**Consultation Response from KC,
Conservation & Design**

2026/90889 J L Brierley, Turnbridge Mills, Quay Street, Huddersfield, HD1 6QT

Discharge of details reserved by conditions 5 (Building Recording), 6 (Demo Method Statement), 7 (Chimney Method Statement), 8 (new walls and/or other structures adjacent chimney) on previous permission 2025/91645 for Listed Building Consent for redevelopment of site for mixed-use E(g) (i, ii and iii) and B8 including: demolition of buildings and re-cladding of southern elevation of retained adjoining building; retention, conversion and renovation of existing mill/office/workshop/engine house building including alterations; erection of two new buildings; formation of two vehicular access points, service yard and parking areas; and other associated works

Section Through

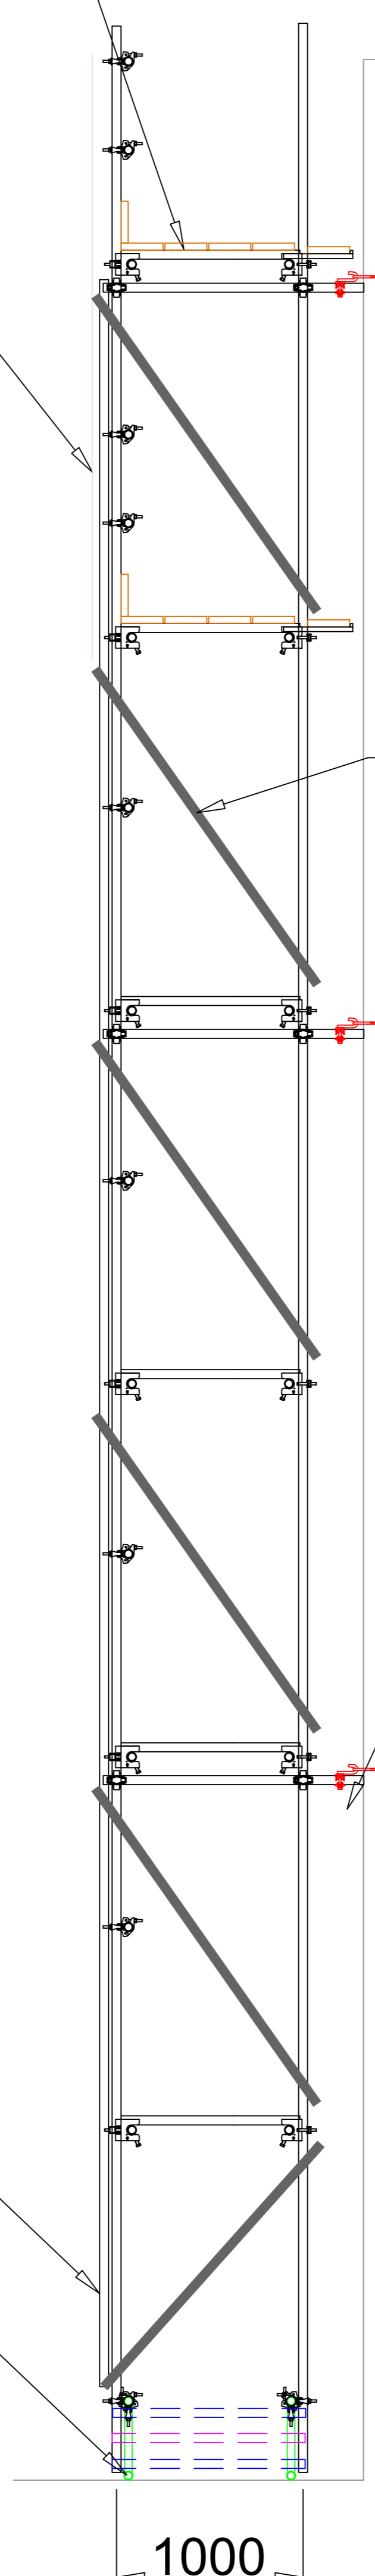
The Demolition Method Statement clearly sets out the methodology and sequencing of demolition across the site. It appropriately details the erection of scaffolding to support the demolition of Building B. However, it is recommended that demolition of Building B should not be undertaken until such time as funding is secured to deliver the replacement building, to avoid leaving the site in a partially cleared or harmful state which could impact the setting and significance of the heritage asset.
